From: [REDACTED]
To: [REDACTED]
Cc: [REDACTED]
Subject: RE: Foreman Homes Site at Church Lane, Climping
Date: 16 October 2025 14:07:03
Attachments: [image010.png](#)
[image012.png](#)
[image013.png](#)

I am the civils consultant working on the above, where it is proposed that IWNL will adopt FW and SW sewers. The planning Authority has requested that the surface water drainage on the eastern part of the site includes an element of infiltration drainage (permeable paving) but due to the variable nature of the soil, there would need to be an overflow to the S104 surface water sewers.

Drawing Title **Domestic Drainage Layout**
Sheet 2 of 22

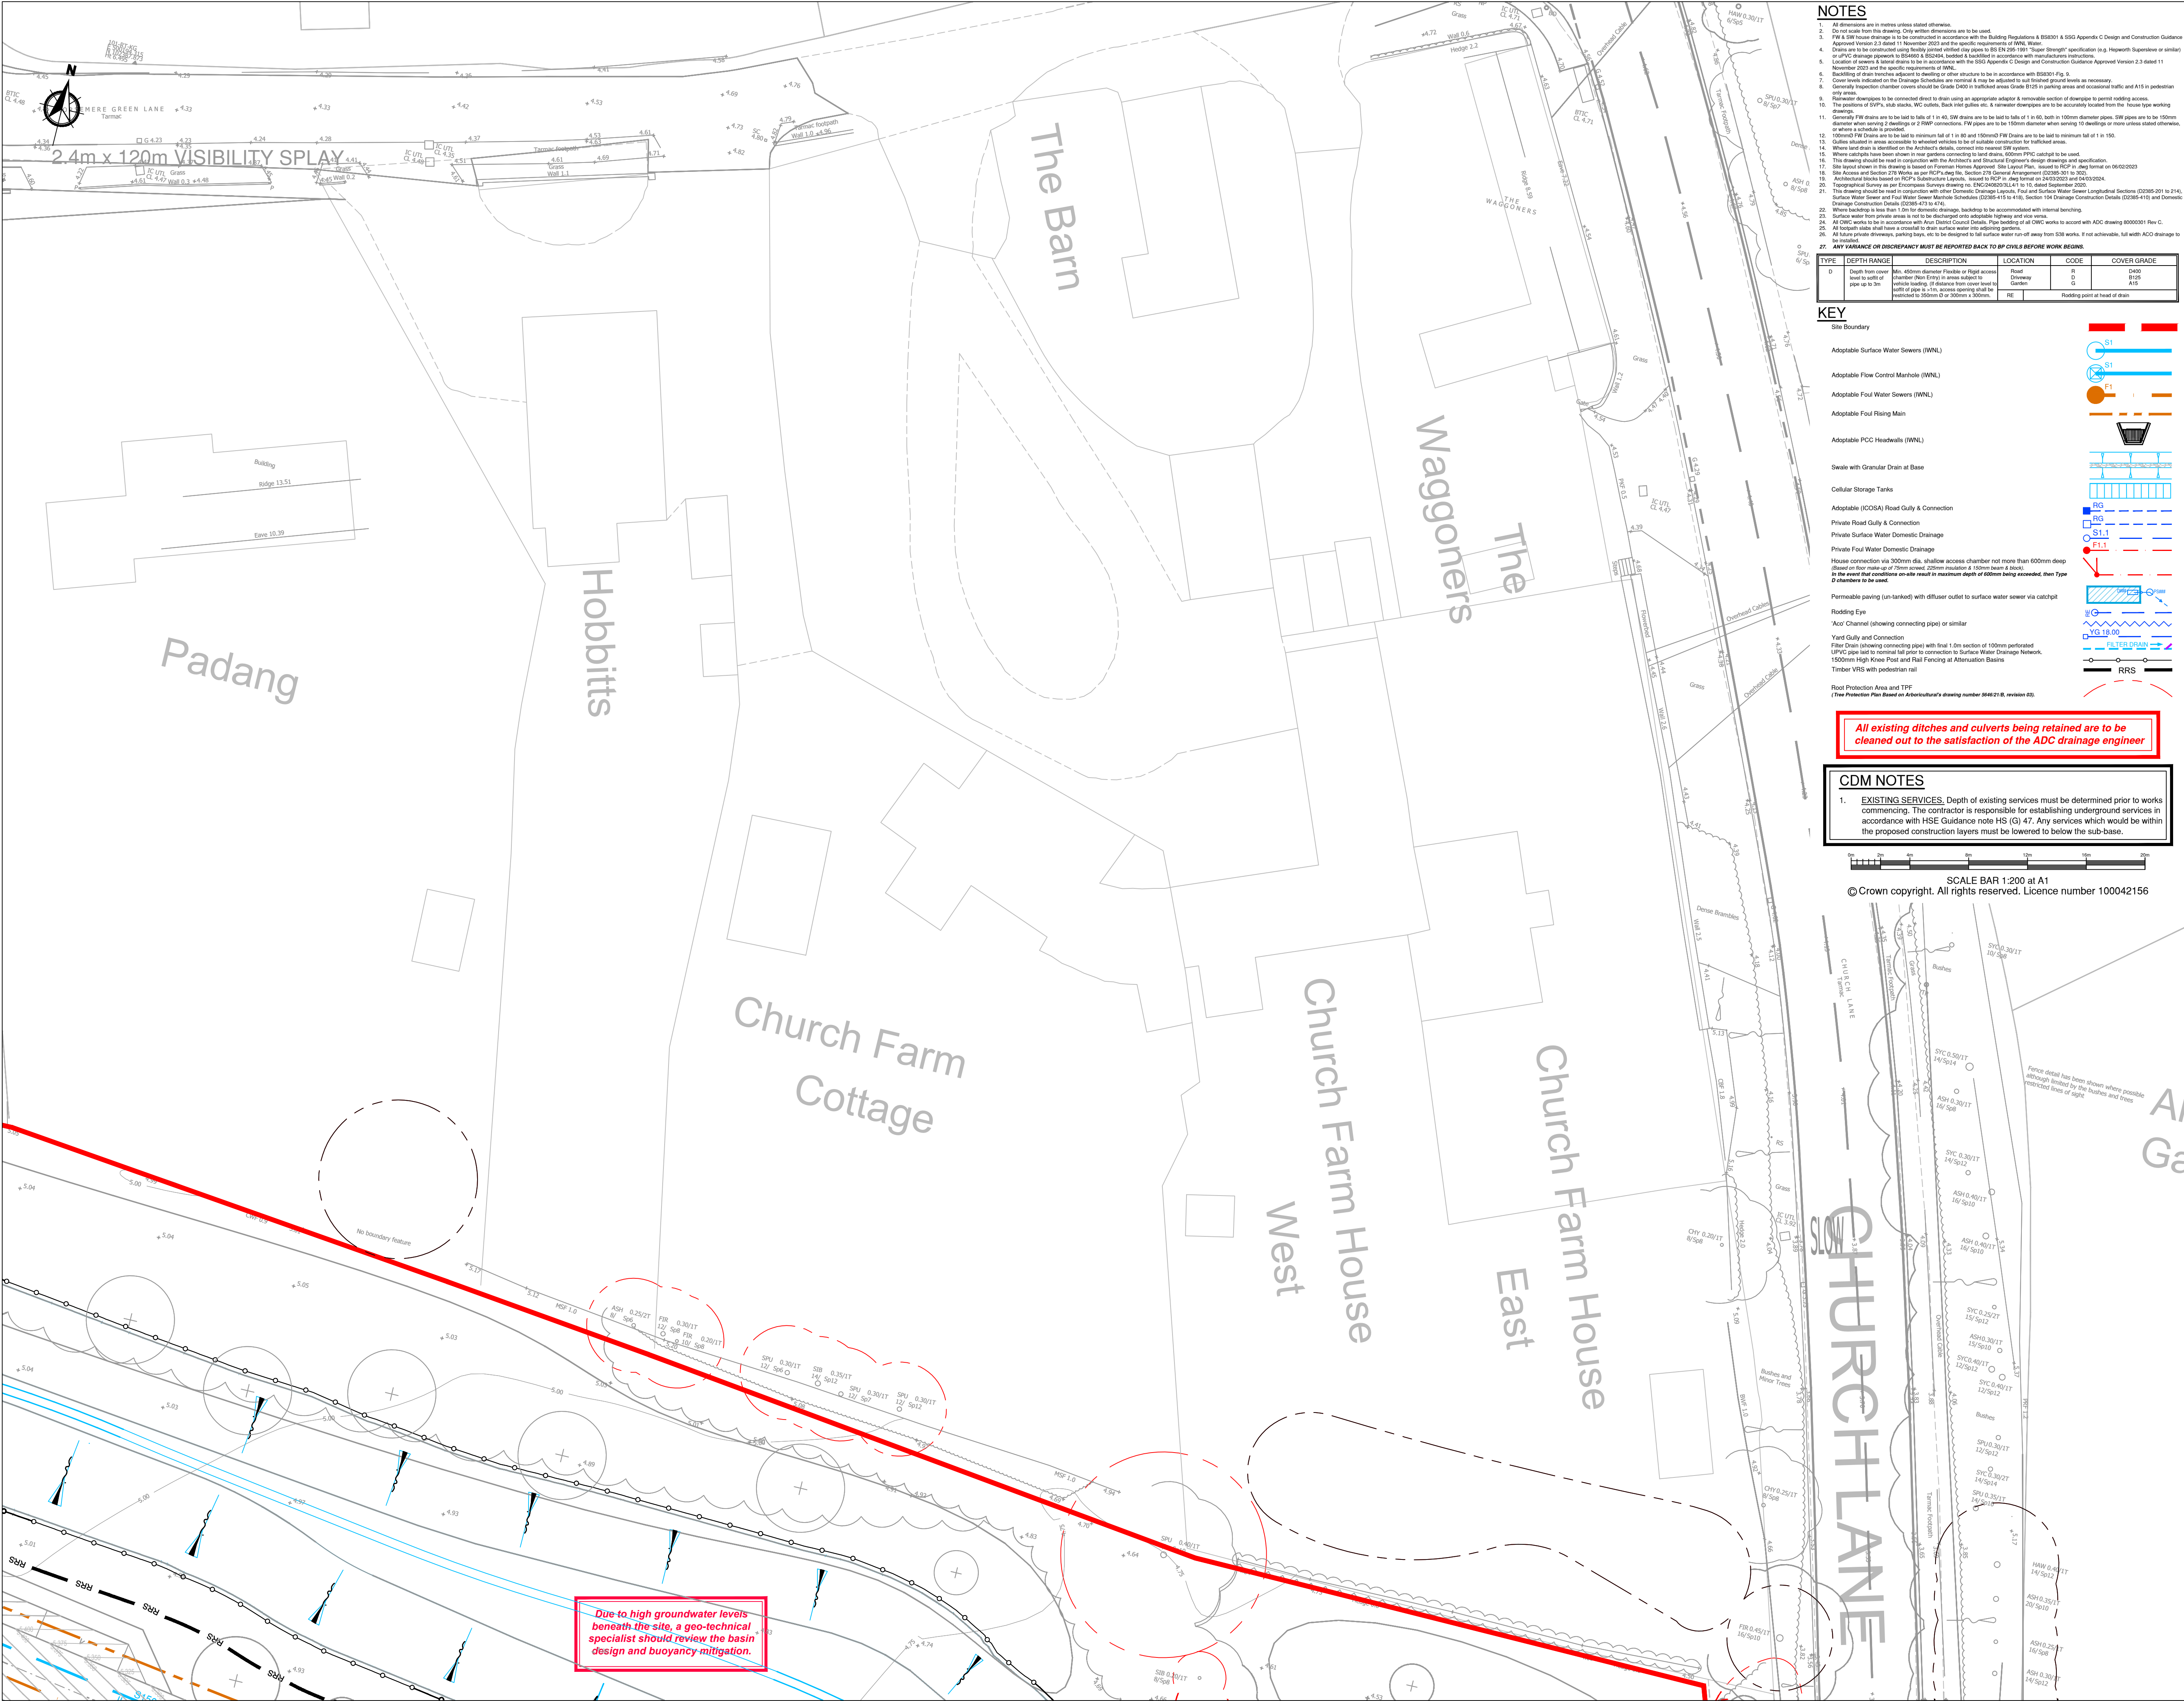
I have reviewed the provided S104 layout and for further review, could you please provide a cross section of the permeable paving that indicating the Groundwater levels to the lowest proposed permeable area?

Additionally, please note that IWNL does not adopt mains proposed underneath the permeable paving, except this permeable area located within a roadway with a S38 agreement and as required by the local authority/highway authority.

The groundwater depth on the eastern part of the site has been recorded at depths in excess of 1.5m, please can you confirm if IWNL would accept overflows from un-tanked permeable paving to the proposed S104 surface water sewer? The extent of the permeable paving is likely to be as shown on the attached drawings.

I have discussed this our technical specialist, and I can confirm that IWNL is able to accept the proposed permeable levels as it has minimum of 1.13m freeboard from the ground water levels.

In terms of the relationship of the lowest base of the permeable paving and the highest groundwater level, this would occur in the area around plots 1-16, where the base of the permeable paving is at a level of 4.83m AOD and the groundwater is at 3.7m AOD, so there is 1.13m freeboard, would this be acceptable?
